28 August 2019

Arboricultural Impact Assessment
26 Mann Street, Gosford.

I have reviewed the site survey dated 5 July 2019 by Veris, and EW Tree Impact Sections dated 26 August 2019, by DKO Architecture. These sections are attached to this report at page 11 (last page).

Proposed Ground Floor
DKO – Revision: P4 (13/08/2019).

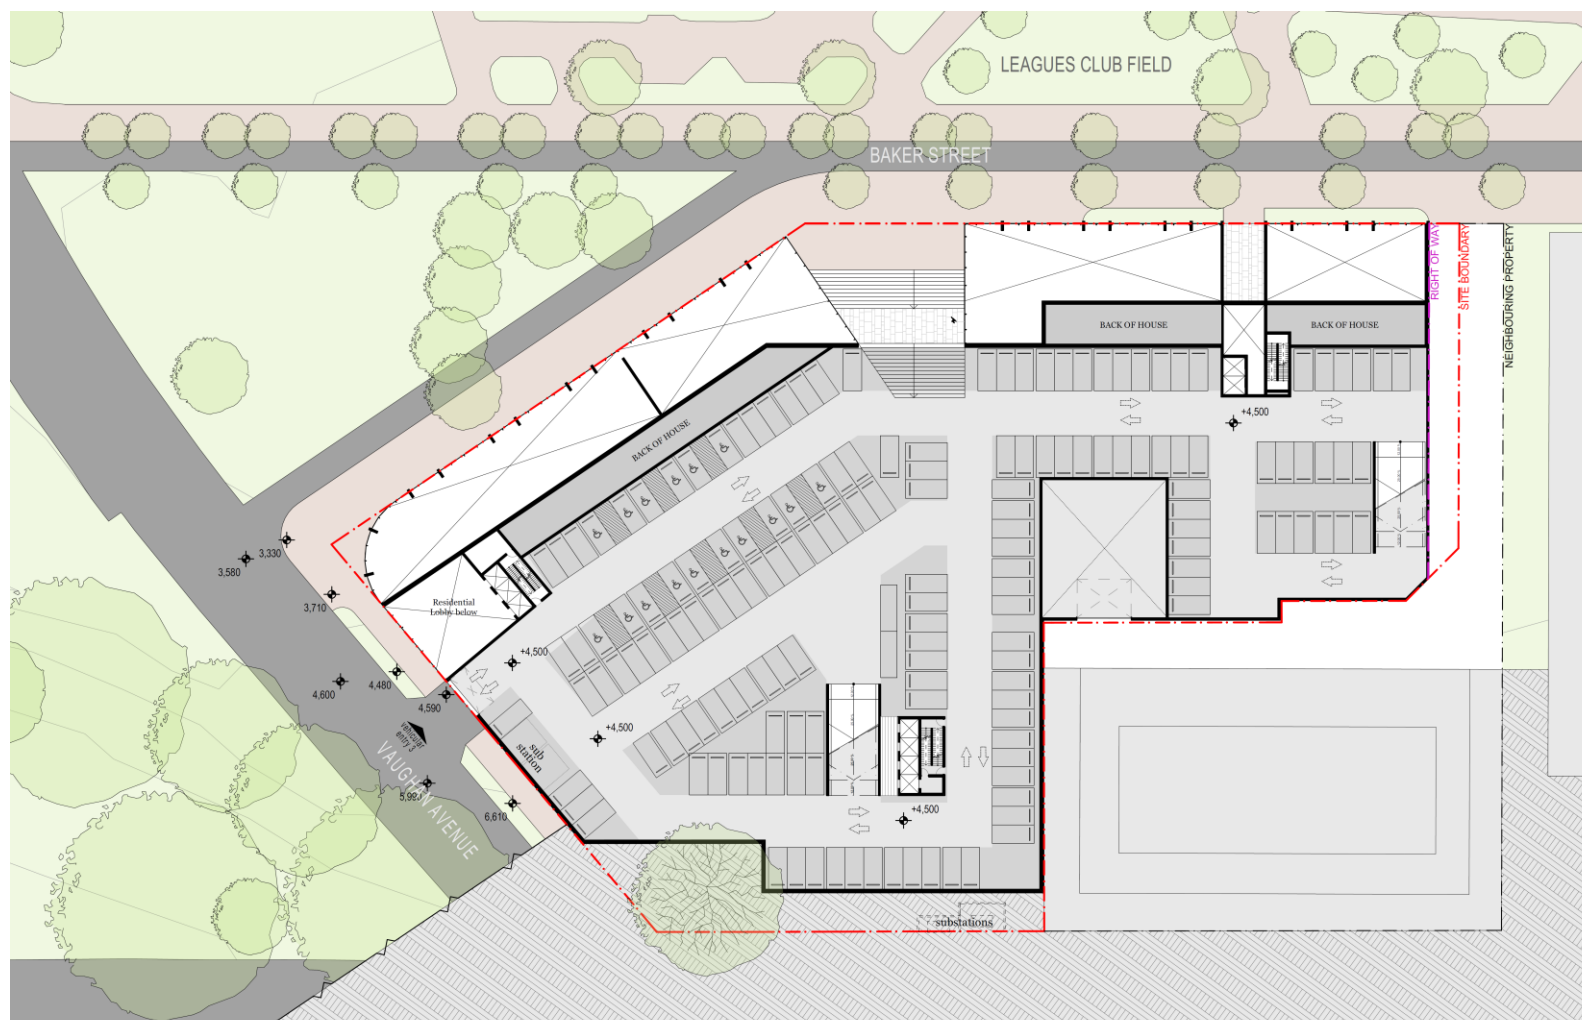
In addition, works cannot include bulk excavation within or at the edge of the tree's Structural Root Zone due to the likelihood structural support roots are encountered and severed, potentially affecting the tree's anchorage in the ground (Figure 1).

The proposal indicates basement excavation beyond the crib wall and, given the existing depression or excavation, it is my opinion the proposed offset to the basement excavation of approximately 7m is acceptable and is unlikely to affect tree health or stability (Figure 1).

The manner in which the proposed excavation is managed to prevent further encroachment is crucial to maintaining the tree. Shoring of the sandy soil must be in place to prevent further soil collapse, and over excavation must be limited to remain clear of the crib wall. As there are fig roots entwined into and around it, this crib wall must be retained adjacent to the tree to prevent further root damage and loss, and an engineer may be required to provide advice in regard to stabilising this wall.

Subsequent to advice, the uppermost proposed basement floor within the DTPZ is to be deleted. The lower two basement floors will be undercut to limit disturbance to the existing soil within the tree's DTPZ.

The methodology includes driving horizontal members into the soil and shoring and/or stabilising the area prior to removal of the soil. The upper surface remains undisturbed. As long as 1200 – 1500mm of the existing soil depth can be retained in the DTPZ the tree is unlikely to experience any adverse disturbance or damage to its root system.

- The existing crib wall is to remain in place within the notional Tree Protection Zone offset (i.e. within a 15m radius of the tree).
 - No fill or introduced soil media greater than 150mm depth shall be introduced between the existing crib wall and the tree, including the Designated Tree Protection Zone (i.e. the tree protection area identified in Figure 1).
